MEMORANDUM

SUBJECT: SP-17-001/ CDR-16-007 – Falcon Marketplace
Fourth Submittal

Preliminary Plan

EXISTING DRAINAGE CONDITIONS

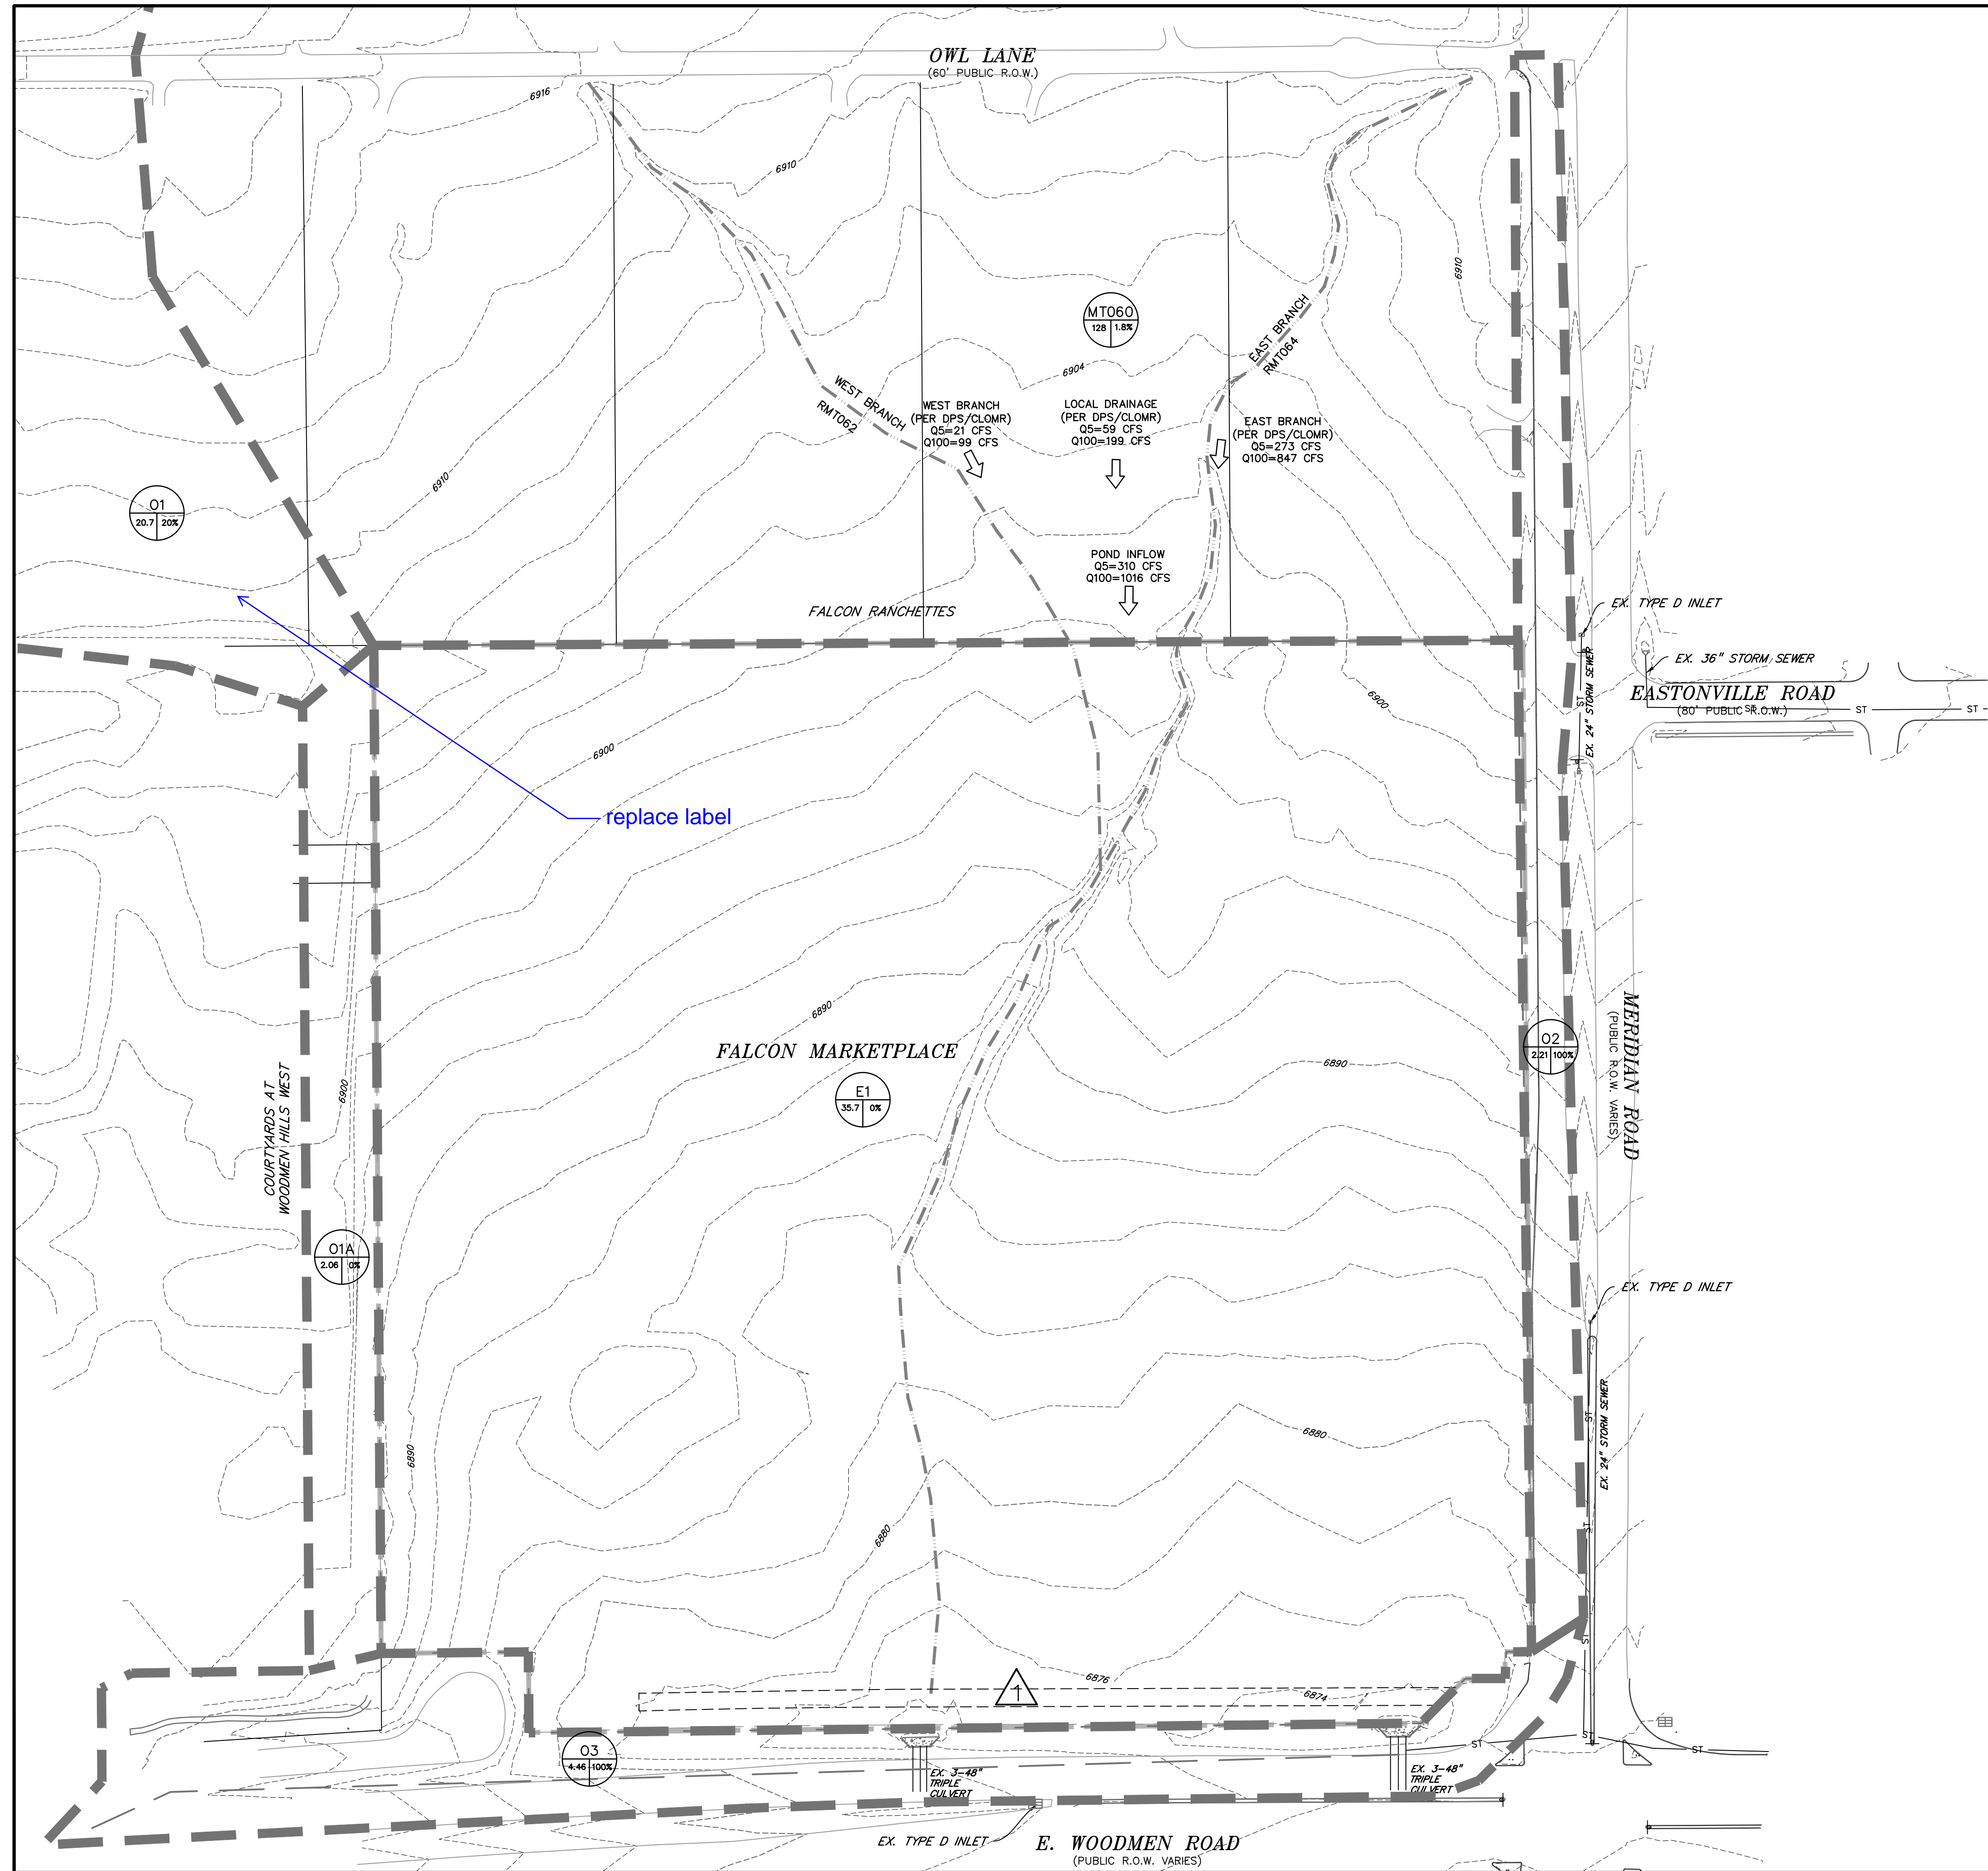
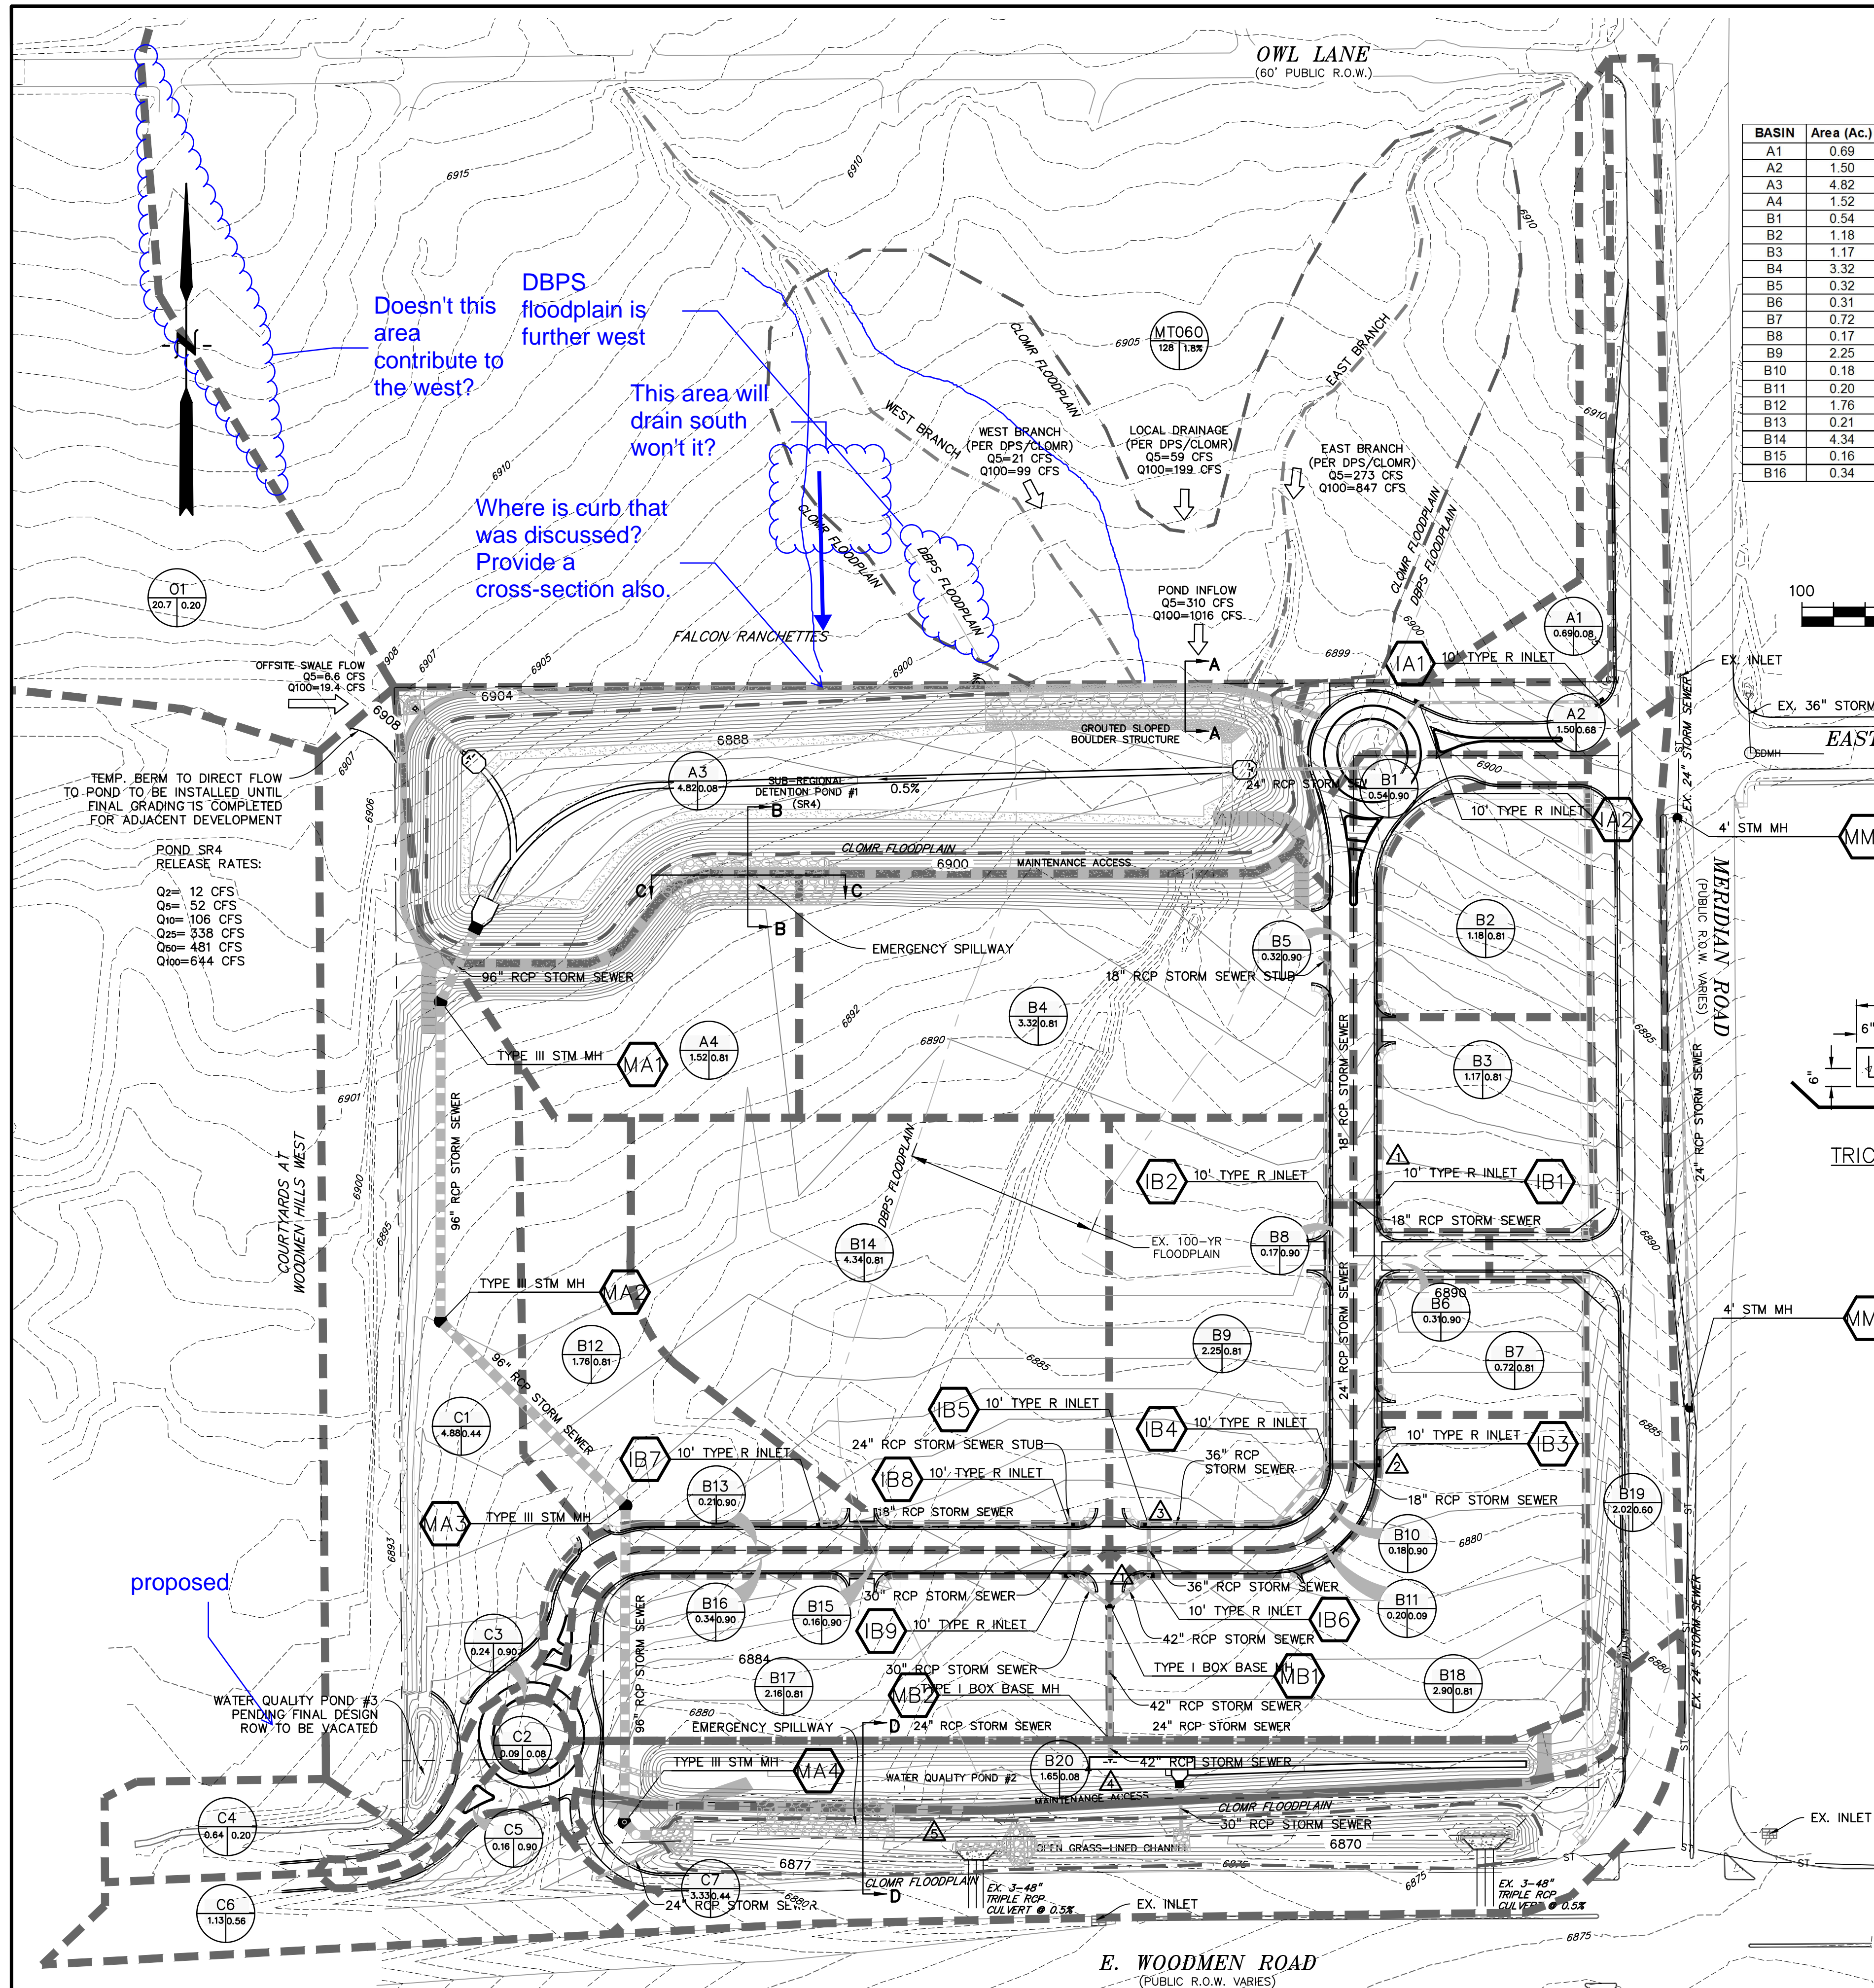
- c. **Resolved**
 - d. Provide a design point summary of 5- and 100-year flow rates at all surface and pipe design points on both the existing and proposed plans. Partially resolved; address per local basin and DP redlines. *Comment remains; see redlines regarding flows from the north.* **Comment remains. Unresolved.**

SUB-REGIONAL POND #1 (SR4)
 PROJECT NO. 20988-00CSCV
 DRAWING NO.

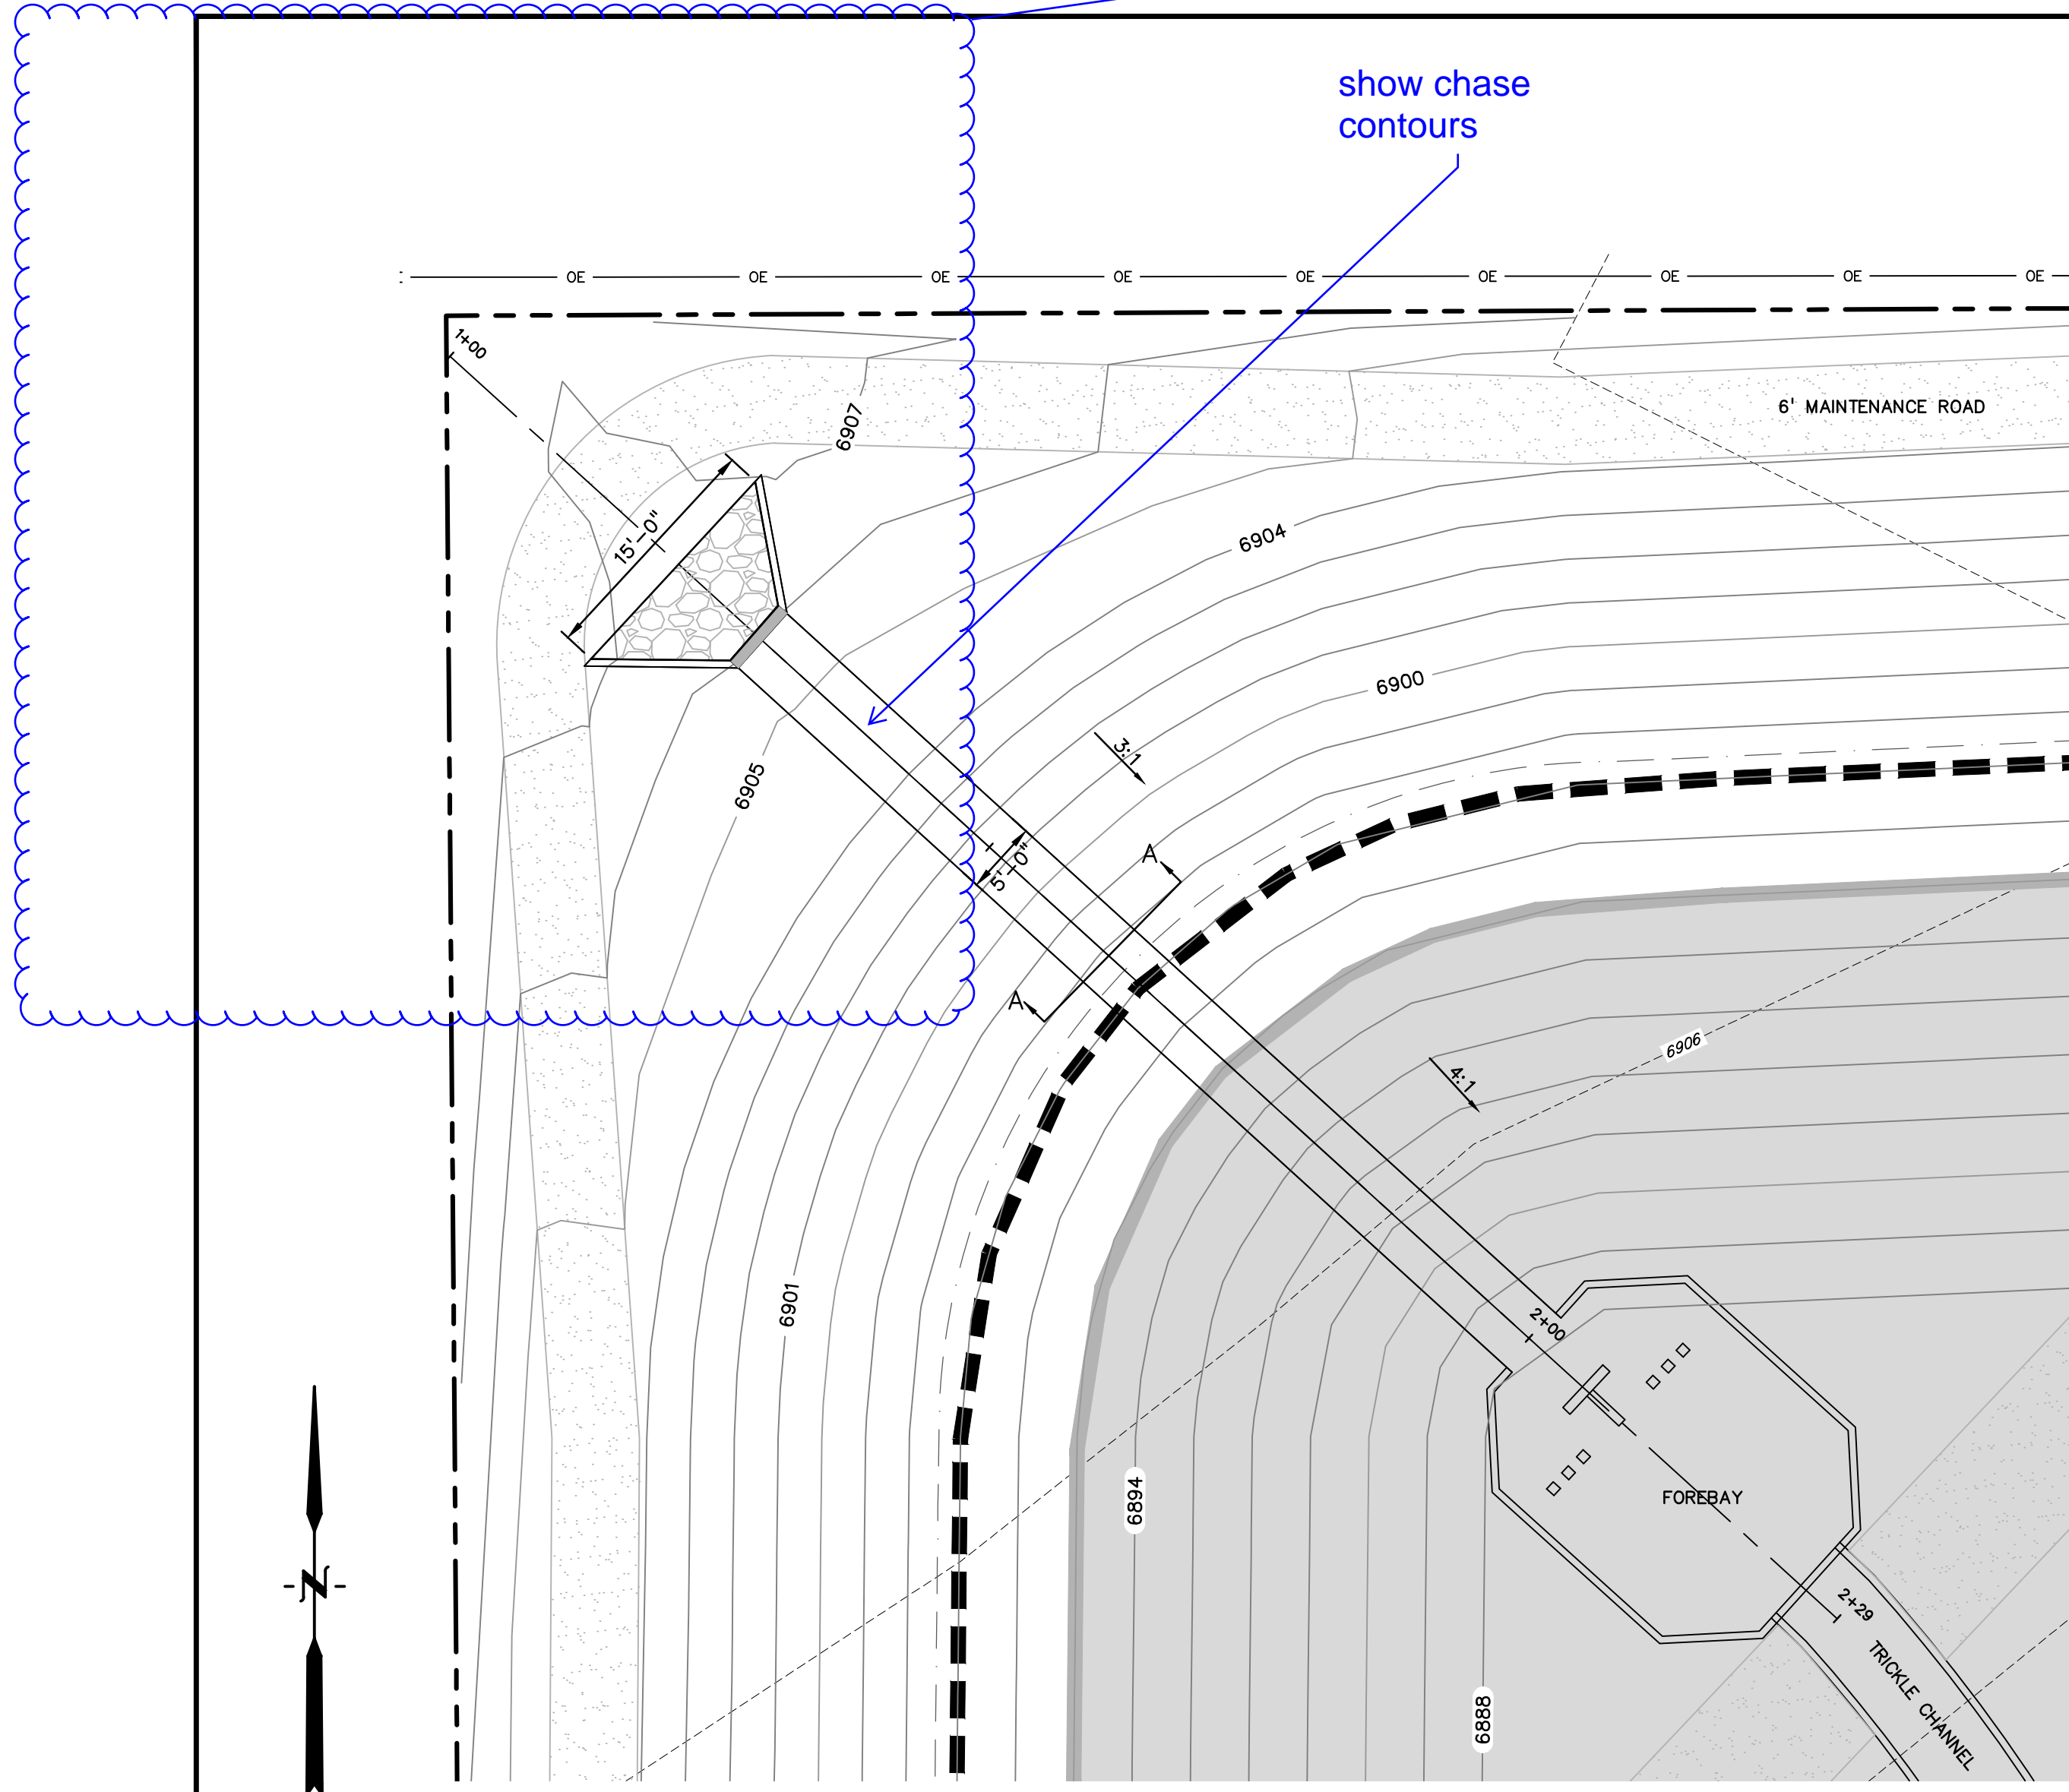
- c. Consider replacing the proposed area drain and pipe at the northwest corner with a swale along the north property line to the proposed rundown. Maintenance access appears likely to be difficult as proposed and the geotech. study recommends “properly designed drainage swale” at the tops of excavation slopes. Partially resolved; stabilization of and maintenance access to the 3:1 (and steeper?) excavated slope along the north side of Pond SR4 will need to be further addressed with the final pond design. *(If the extent of overlot grading includes the slopes, this needs to be addressed with overlot grading.)* **Comment remains; access road design, offsite grading (requiring easements) sheet flow locations and rundowns and the concrete rundown need additional detail to ensure adequate access and functioning. Unresolved.**
